From: Tom Errico <thomas.errico@tylin.com>
To: Jean Fraser <JF@portlandmaine.gov>
CC: David Margolis-Pineo <DMP@portlandmaine.gov>, Katherine Earley <KAS@port...>
Date: 2/11/2016 9:46 AM
Subject: 1363 Washington Avenue/Taco Bell - Preliminary Traffic Comments

Jean - I have reviewed the application materials and offer the following preliminary traffic comments.

Not Approved for Construction
Drawing Title
Layout & Materials

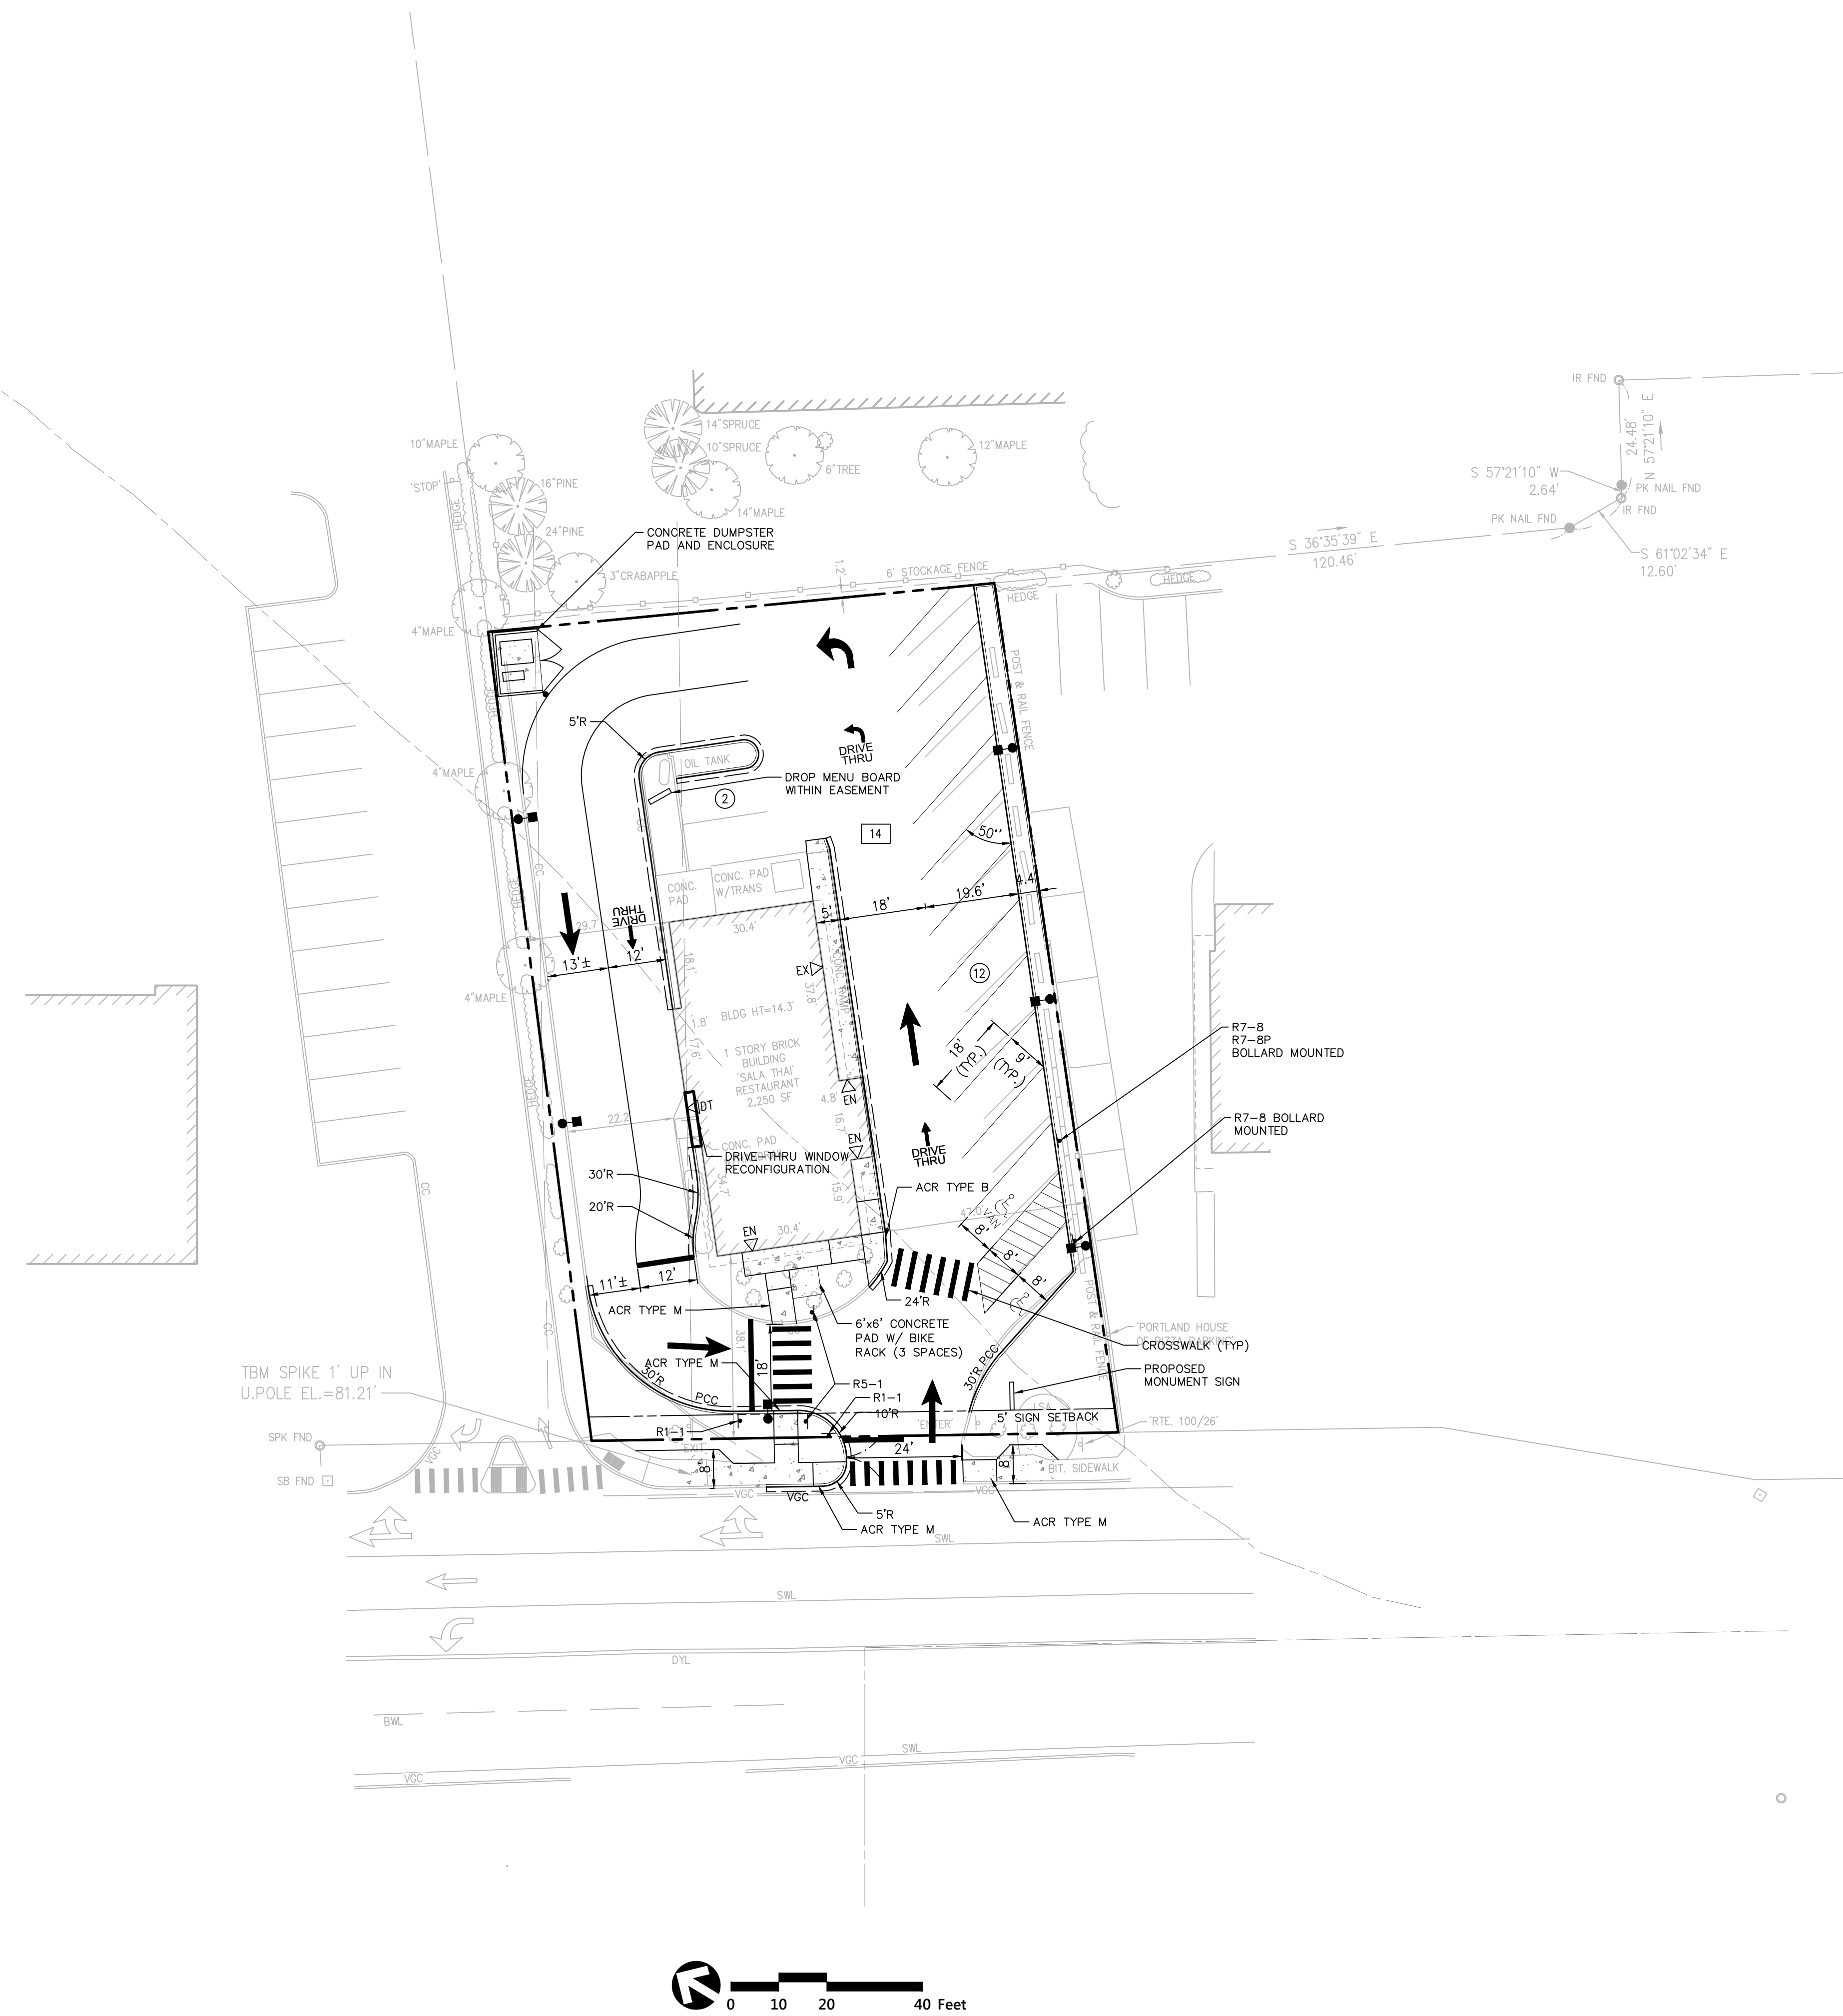
* Sidewalk improvements along the property frontage on Washington Avenue shall be included. Two utility poles are located in the sidewalk and their location obstructs pedestrian accessibility. I would suggest the sidewalk be widened toward the site to accommodate a 5-foot clearance to the face of poles.

* The applicant should provide dimensions for all on-site parking lot elements and note whether City standards are met.

**BICYCLE RACK SPECIFICATION - BIKE HITCH**  
 N.T.S. Source: VHB LD\_533a

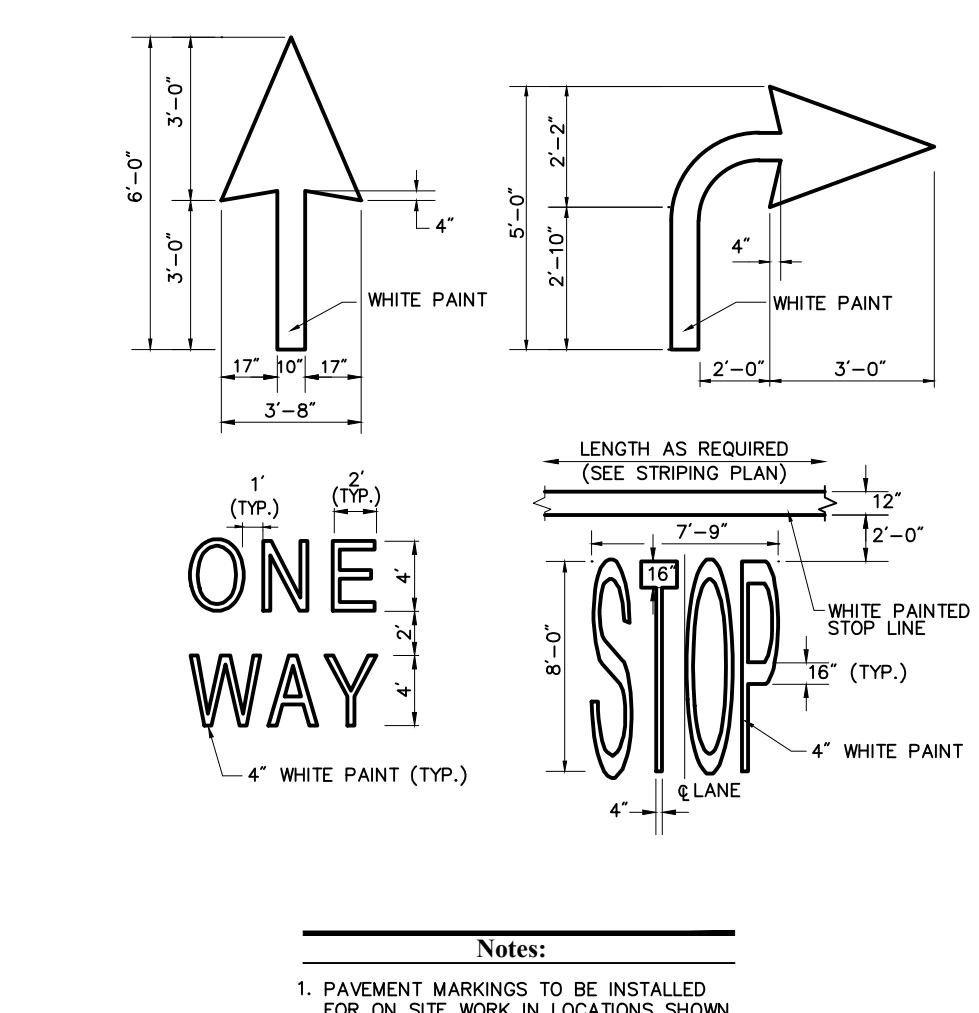
* The applicant should provide bike racks on-site that meet City standards.
